MARSHALL ENGINEERING SERVICES, PLLC

1 July 2020

Subject: 168 Cresthaven Revision

ADDATION	165 CRESTHAVEN RD. SANFORD. NC	CONSTRUCTION SOLUTIONS 211 CLAREMONT ST. FAYETTEVILLE, NC	Marshall Engineering Services 7575 McCartans Ford Linden, NC 28356 910-850-5874 Corp. Licenses P0682
FOUNDATION & FRAMING

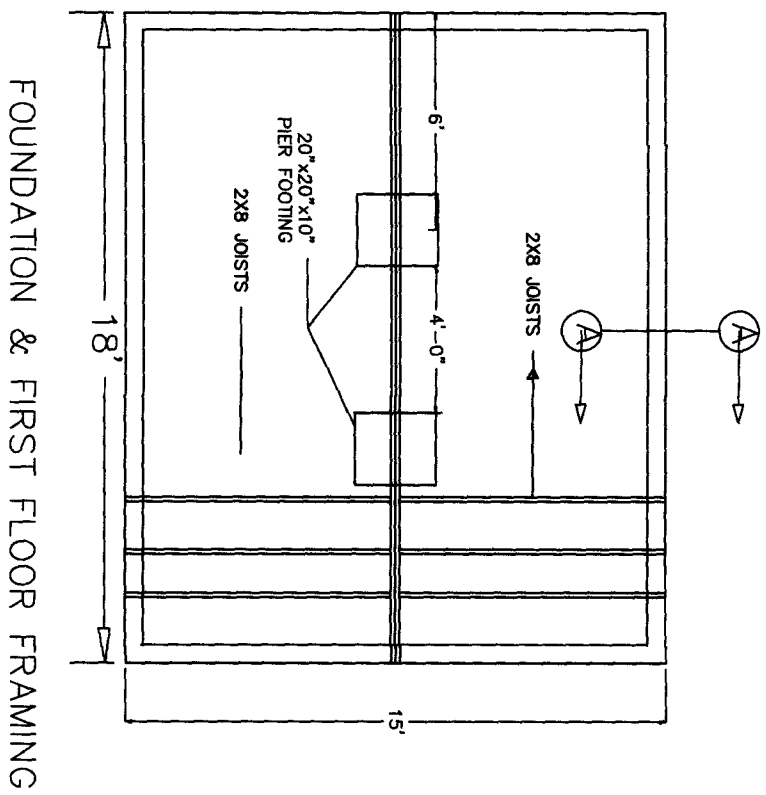
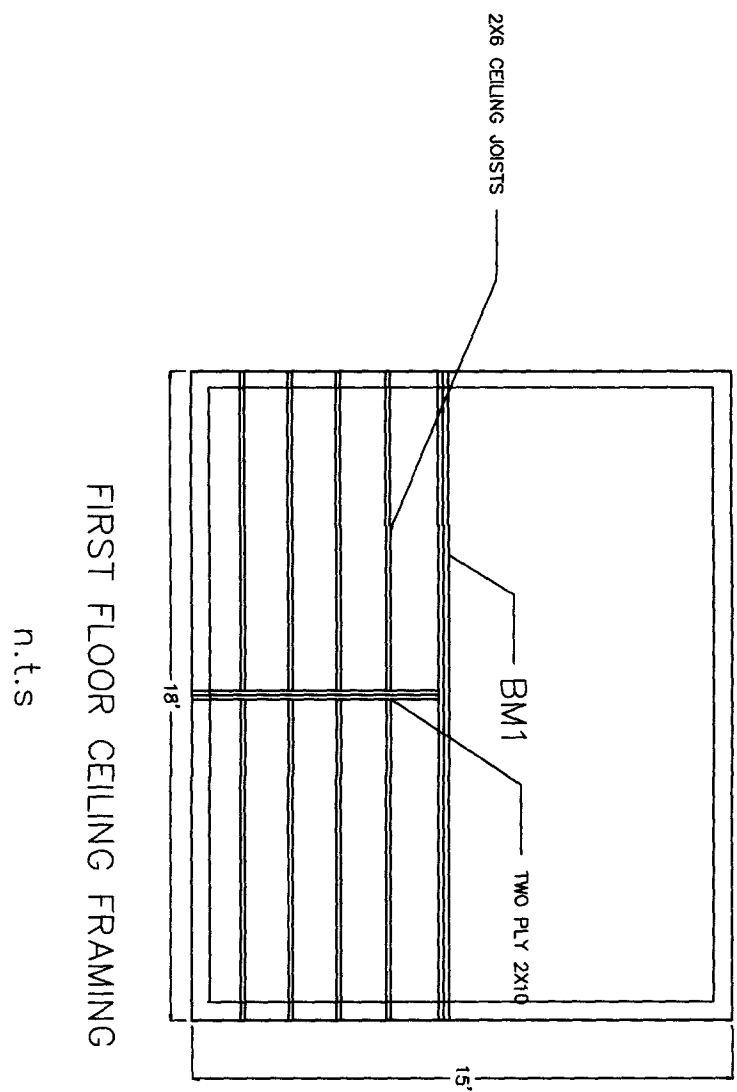
The construction drawings stamped 29 April 2020 show double 2x10 rim joists and double 2x10 girders. The 2x10 material allowed for 2x2 ledgers to support the 2x8 floor joists. Double 2x8 rim joists and double 2x8 girders will be adequate if the joists are attached with metal hangers.
